State of Washington
DEPARTMENT OF FISH AND WILDLIFE

January 20, 2023

SUBJECT: WDFW COMMENTS ON RU-22-00006 Harmon

**MITIGATION SITE PLAN, NOTES, & DETAILS**

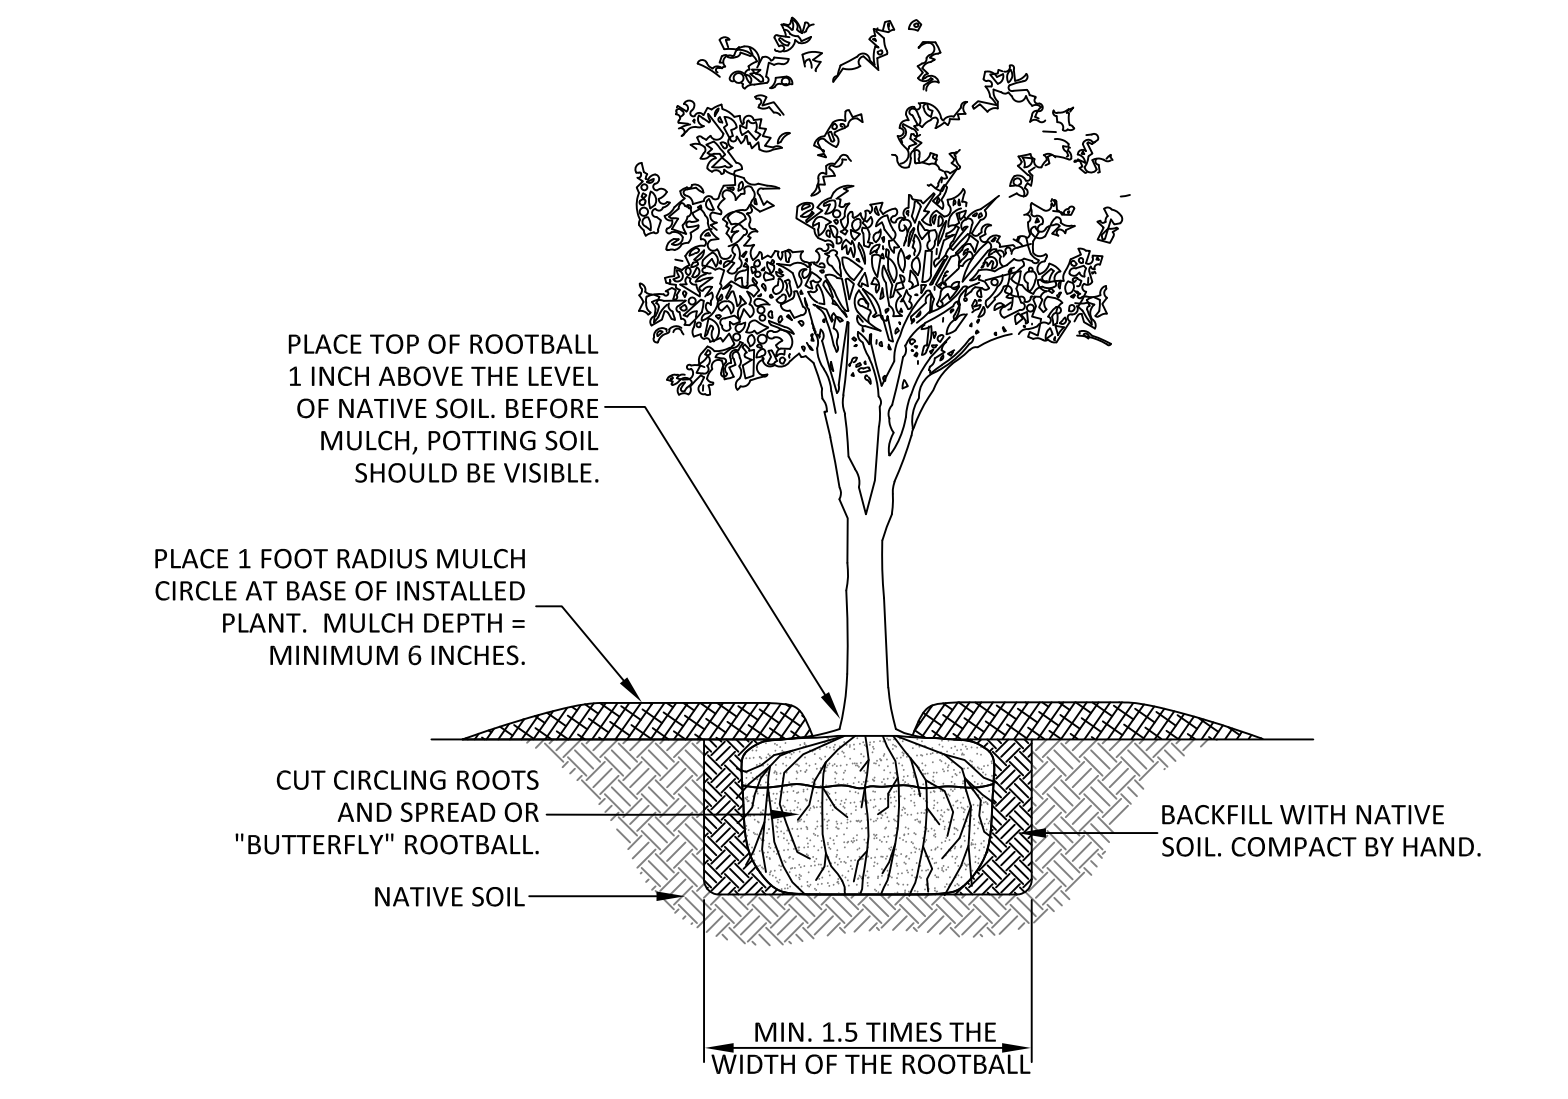
As currently proposed, the impacts to the riparian area where shade is a critical function is 3,892 sq ft. of removed riparian habitat. Clearing in this area is likely to remove multiple mature or semi-mature trees that are contributing shade to the creek. The proposed planting of 12 small conifer trees along the Type N creek does not adequately offset impacts of clearing along the Type F creek. In addition to updating the critical areas report to fully identify riparian impacts as requested in this letter, WDFW requests that a revised mitigation plan needs to be developed that will fully offset the impacts. The mitigation plan should include: 1. Replanting a sufficient number of native site adapted conifers to offset the removed conifers, the planting site should also be as close to the Type F creek as possible. 2. There will be temporal loss of shade from removal of mature and semi-mature conifer trees and planting new smaller trees. The temporal loss needs to be mitigated for. One potential option is placing some or all the removed trees in this tributary stream as shade and cover. Permits from WDFW would be needed for this instream work. Planting of fast-growing riparian shrubs along the creek can also be used to mitigate for loss of shade. WDFW requests to review an updated mitigation plan and is willing to meet on site with the applicant to discuss elements of an updated mitigation plan.

HARMON	PARCEL#: 767835	601 YELLOWSTONE RD SNOQUALMIE SUMMIT	SITE PLAN		1/1	
			OCTOBER 2022	NO SCALE

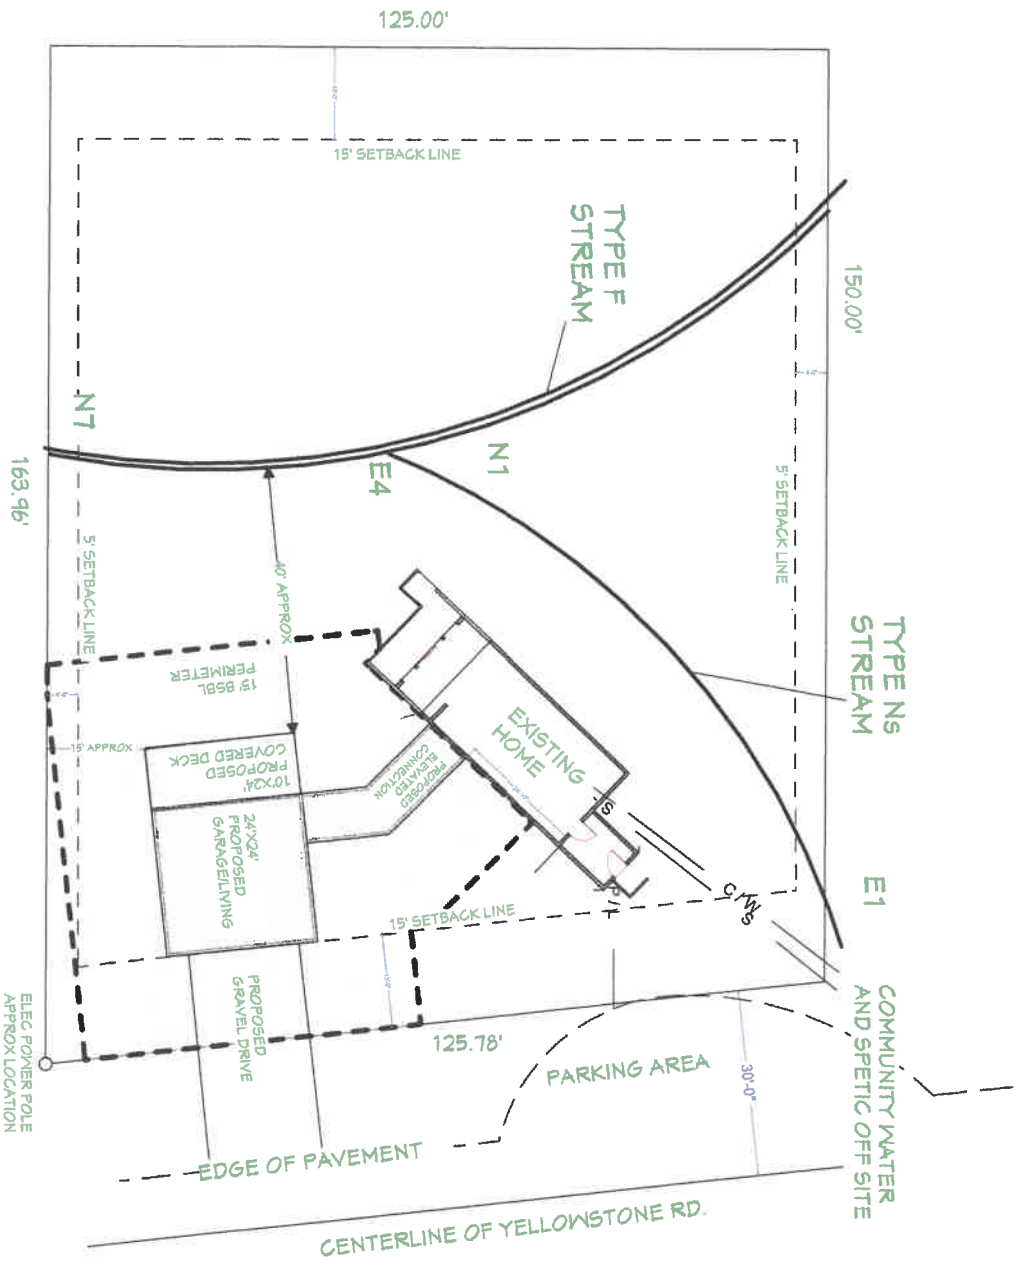
In the critical areas report, the total summation of riparian area impact is 3,892 square feet. The critical area report does not include how many trees and what sizes would need to be removed for this impact. One of the critical elements for maintaining healthy fish habitat is providing shade on the creek. *WDFW requests that the critical areas report be updated to include the trees planned for removal, their size and/or their shade influence on the creek.*

The overall footprint of the proposed building is a large footprint in an important riparian area where there has already been significant reduction due to existing buildings. Thus, additional removal of the riparian area is likely to substantially alter the stream environment. Elements of the proposed building footprint such as the deck or elevated causeway that either could be reduced, eliminated or relocated away from the stream adjacent areas. WDFW does not agree that the current proposed building which includes items such as the deck or the causeway is the minimum necessary impact to the critical area as stated in the critical areas report under question c.ii. *WDFW requests that a revised site plan be developed to further reduce riparian impacts. If it is of help to the applicant and the county, WDFW is willing to have a site visit to help minimize such impacts.*
